# Rezoning Transportation Analysis

Petition Number: 2022-203

Date	Description
4-27-23	First Review (PDM)
07-28-2023	Second Review (PDM)

RZ1.0

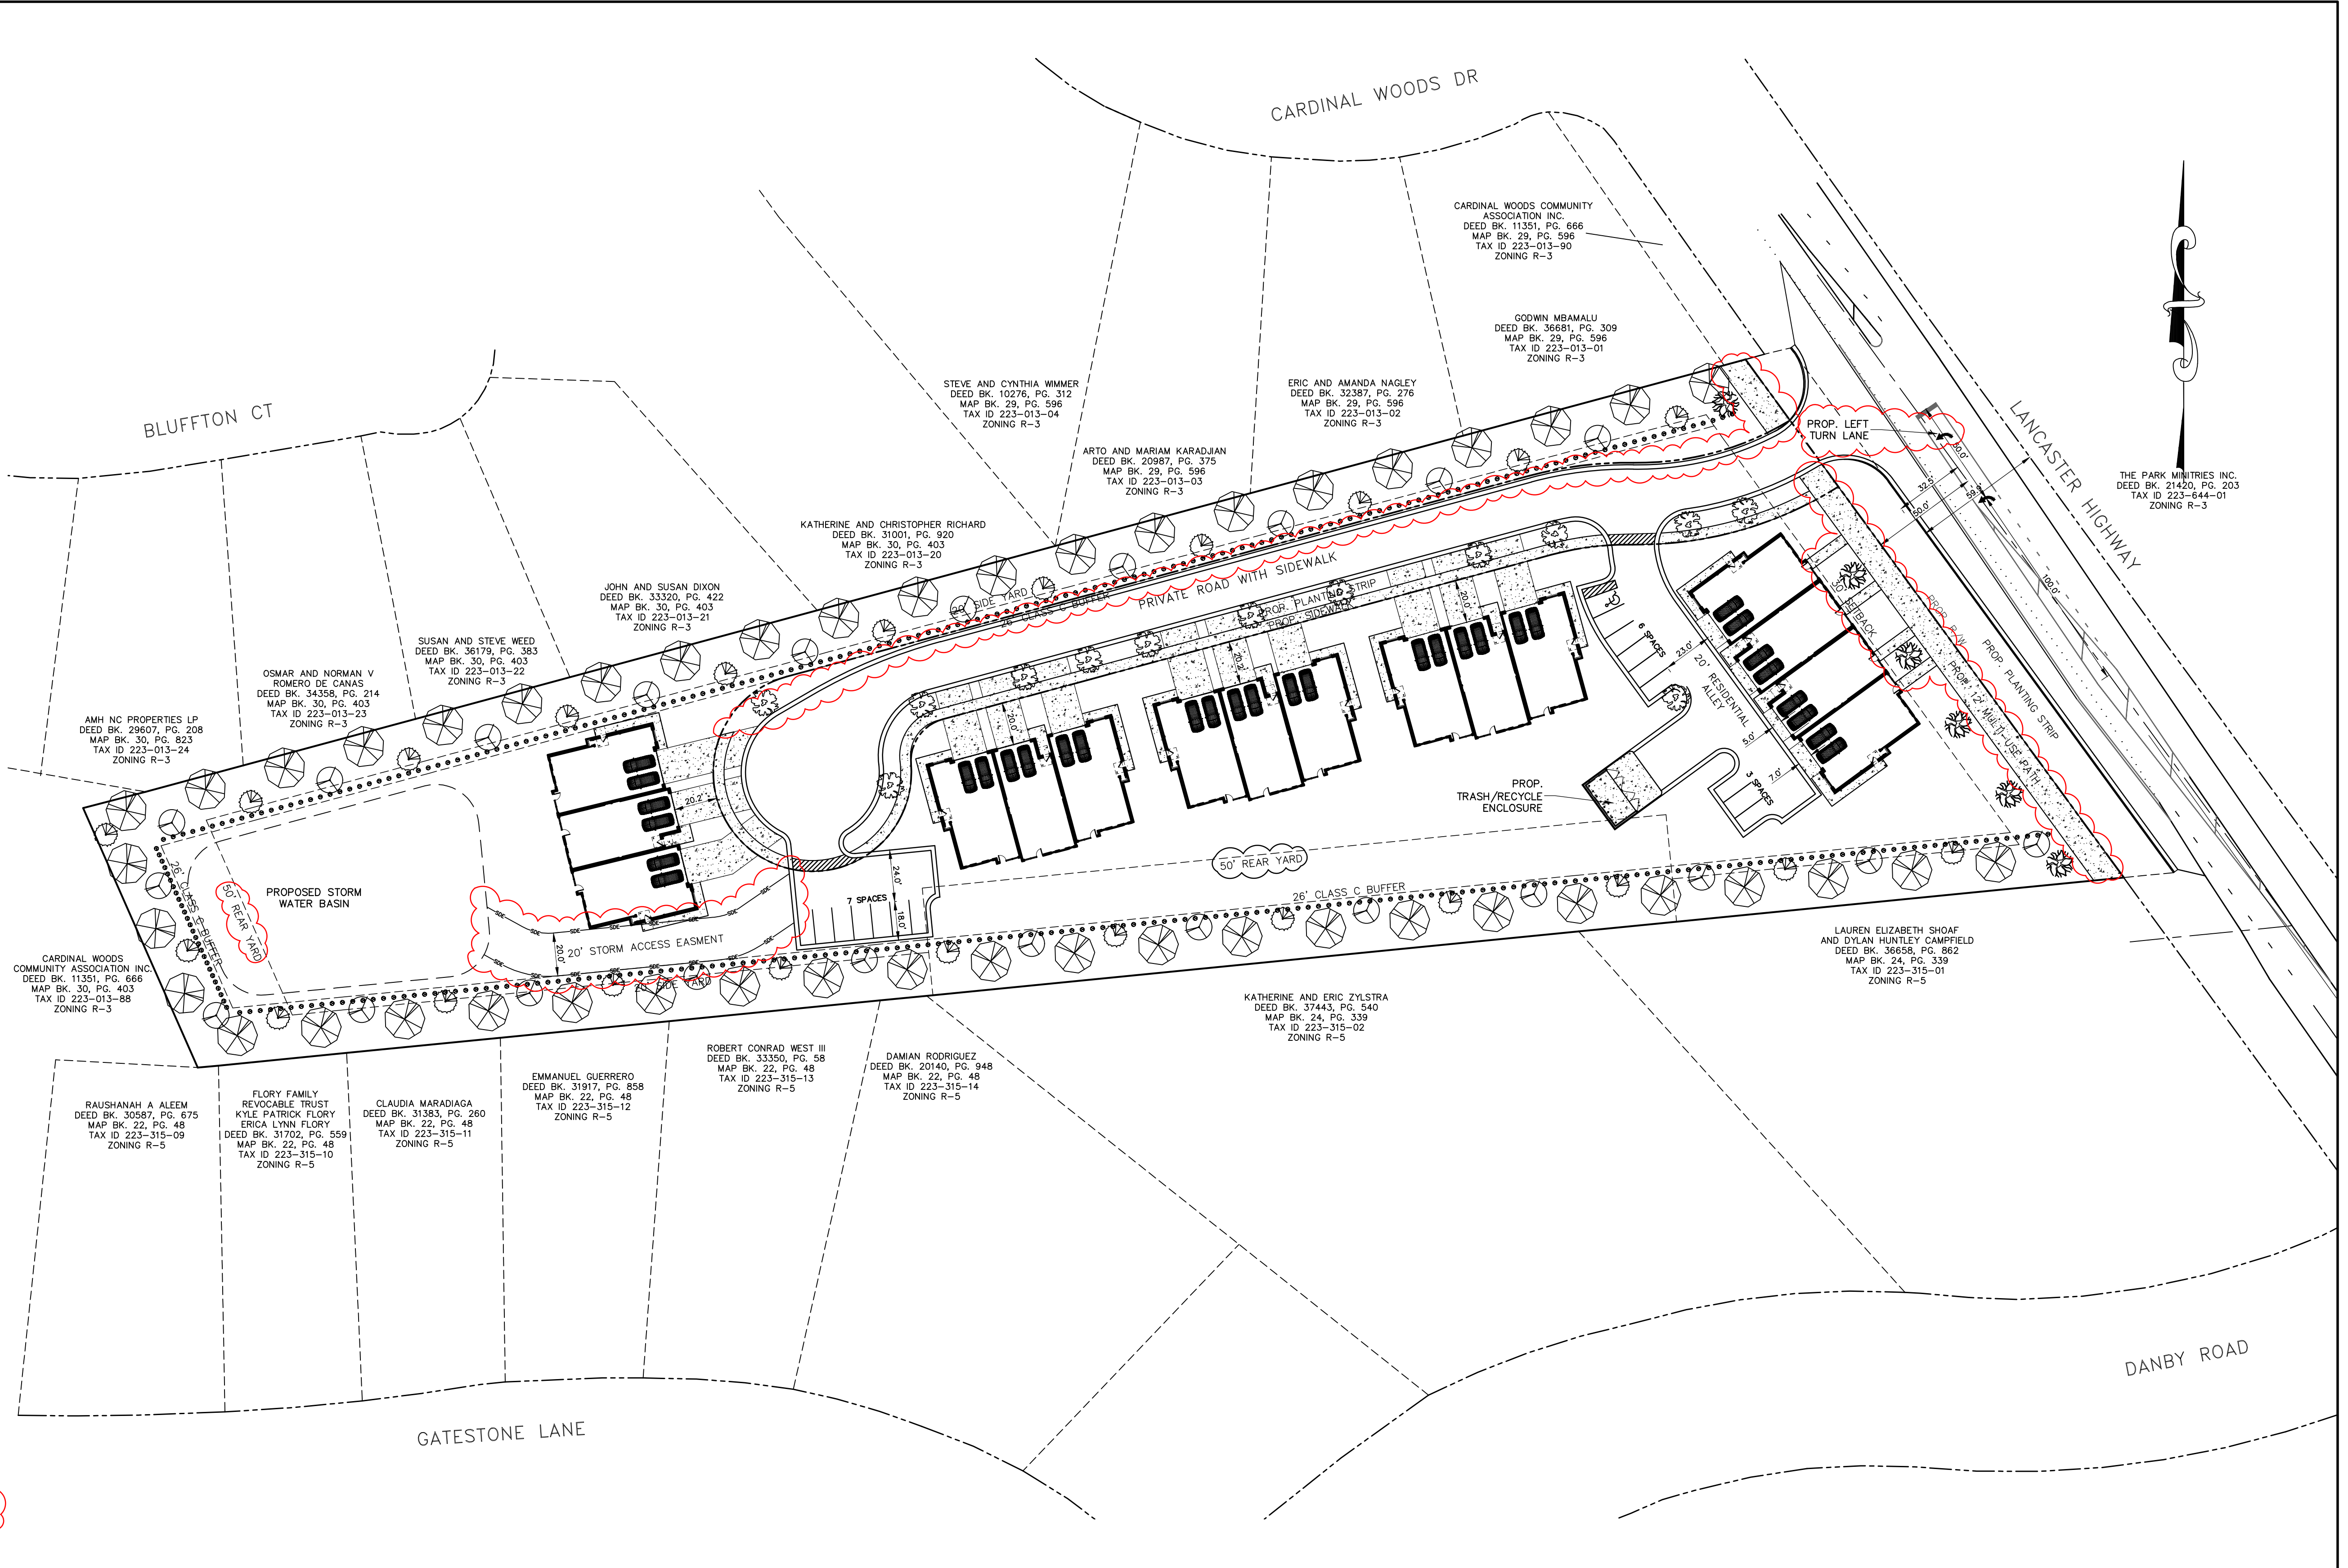
8. **NEW COMMENT FROM 7.28.2023:** Remove stop bar shown at the proposed left turn lane.
